**PLANNING ACT 2008
APPLICATION BY HIGHWAYS ENGLAND FOR AN ORDER GRANTING DEVELOPMENT CONSENT FOR THE A303 SPARKFORD TO
ILCHESTER DUALLING**

SUBMISSION MADE PURSUANT TO DEADLINE 5

South Somerset District Council's Response to the Examining Authority's written questions and requests for information (ExQ2)

FIGURE 2.5  
HAZLEGROVE JUNCTION UNDERBRIDGE  
GENERAL ARRANGEMENT

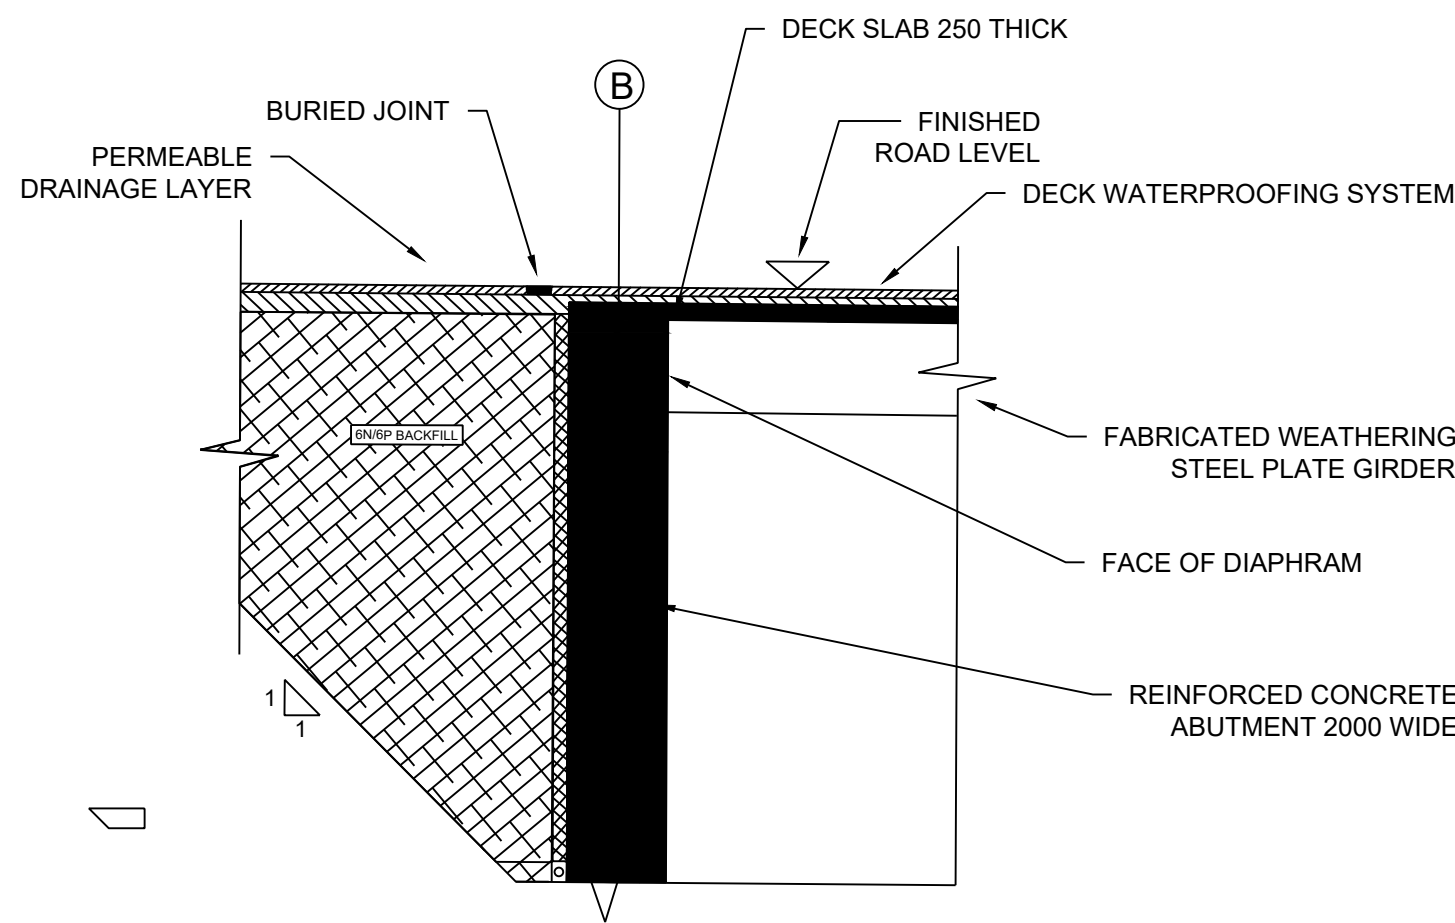
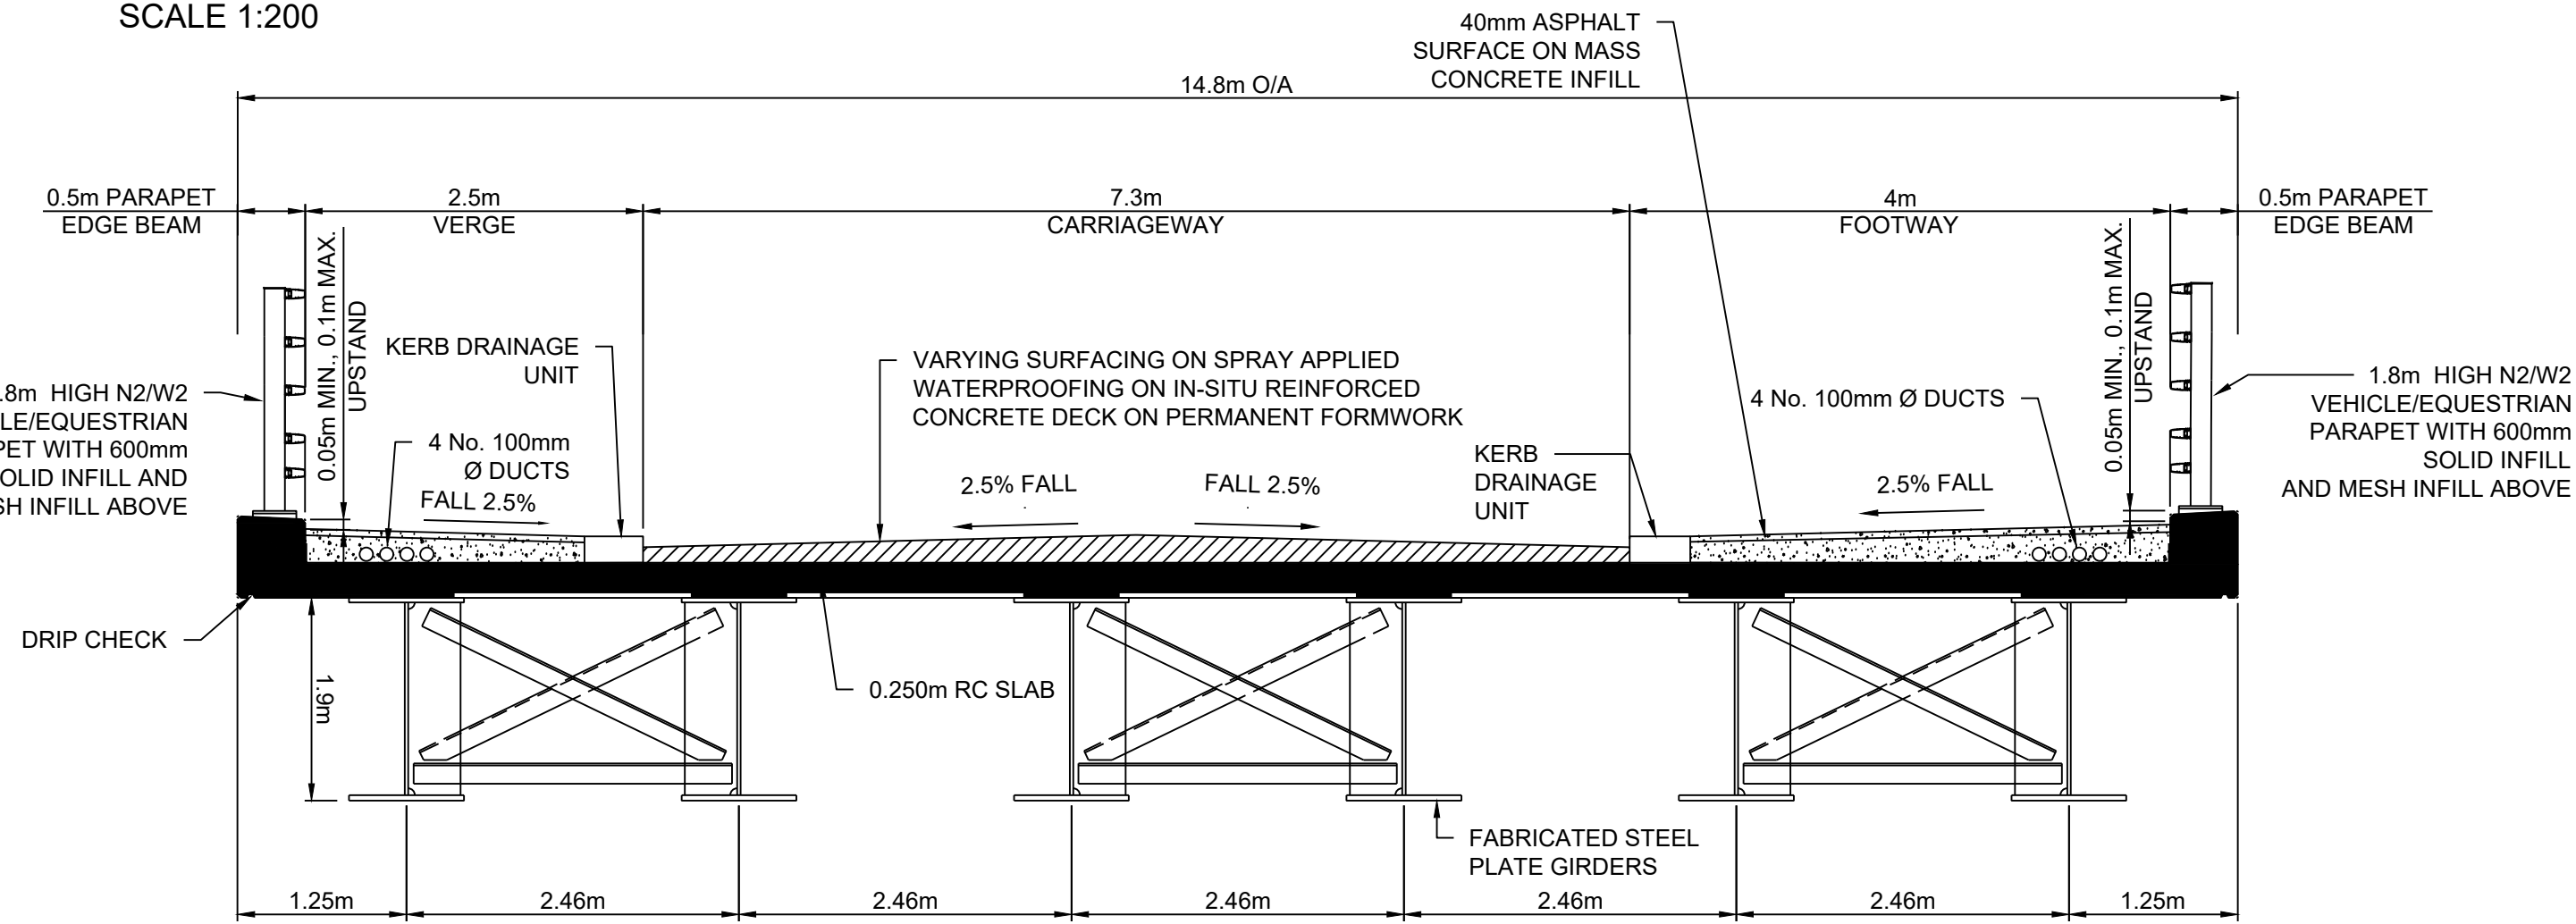
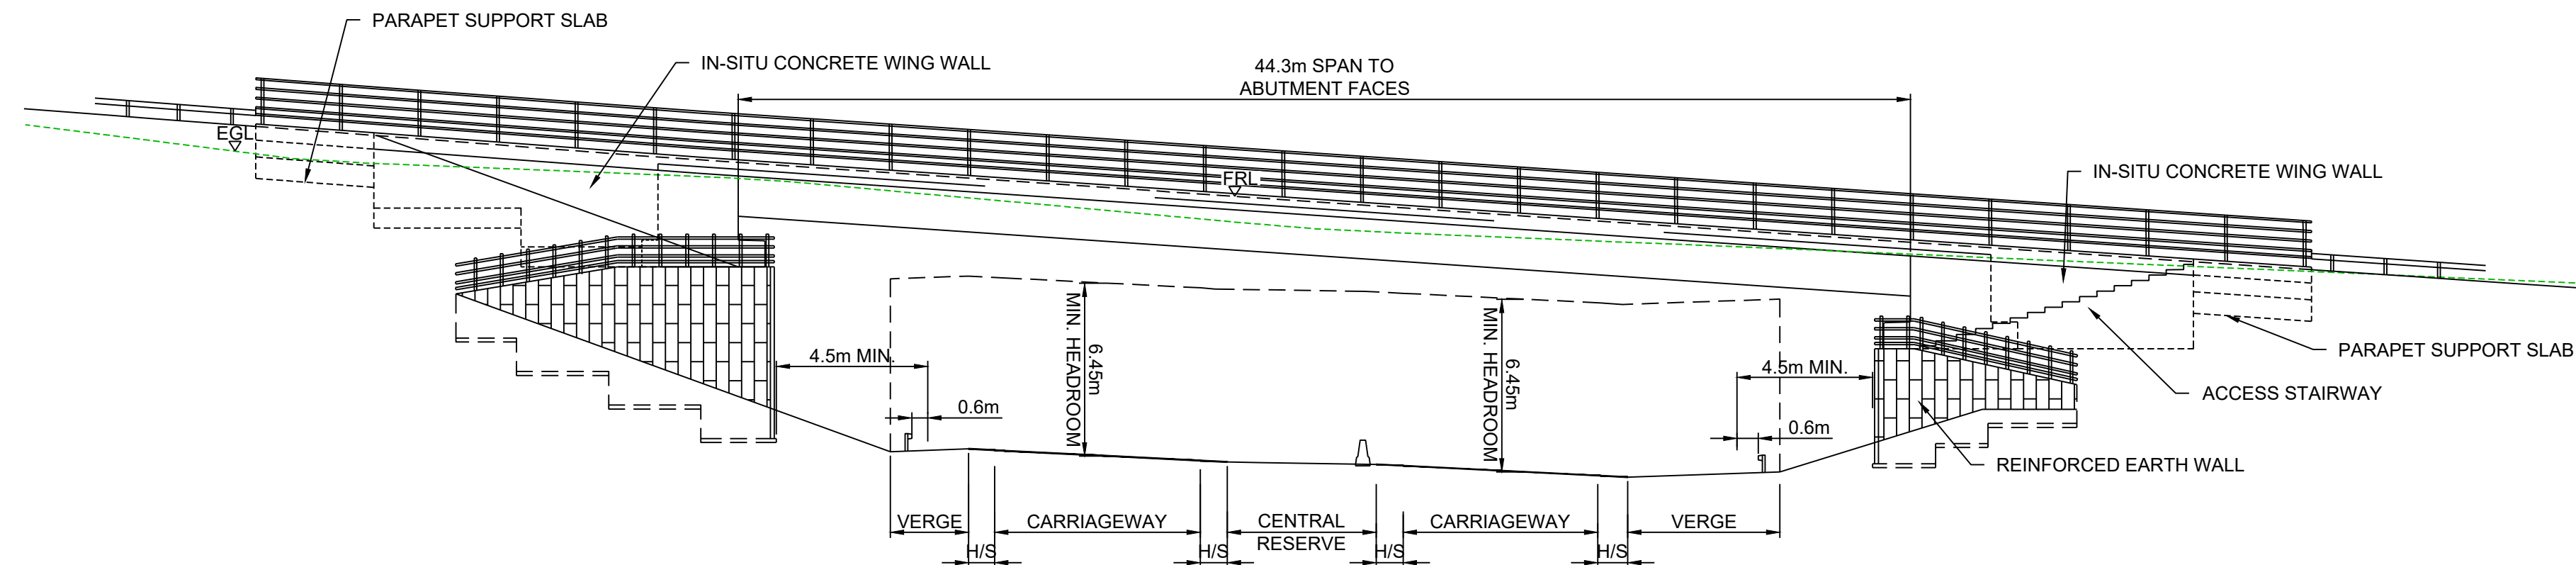
2.6	Socio-Economic Effects on surrounding Communities		
2.6.8	The Applicant	<p>Hazlegrove Underbridge ES figure 2.5 [APP-104] shows the general arrangement of the proposed underbridge. It is unclear from the submitted information what the height and profile of the proposed concrete retaining walls would be.</p> <p>Please could the Applicant submit indicative details of these walls sufficient to illustrate the intended height, profile and appearance.</p>	<p>The Council has made representations regarding its concern with the design and appearance of the under and overbridges. Recent feedback from the Applicant has informed the Council that the submitted designs are the worst-case scenarios for the purpose of the EIA, and that the proposed designs will not be submitted until the detailed design stage under Requirement 12.</p> <p>Due to the prominence of these bridges in the landscape and their association with</p>

ExQ2	Question to:	Question:	
			<p>the character of the district for travellers on the A303, the Council seeks greater assurance that these features will be constructed to appropriate designs.</p> <p>The current outline designs vary in form from the existing bridges on this section of the A303 by being supported on abutments rather than slender piers, which introduces a new form of bridge design and substantial elements of unattractive concrete facing panels.</p> <p>The Council has requested that the design of the bridges should response to the character of the local landscape or A303 corridor, i.e. use of local stone facing panels or pier substructures.</p> <p>The Council requests reassurance at this stage that the final designs will be appropriate through a new Requirement for the bridge designs supported by an agreed background documents establishing the parameters for the designs.</p>
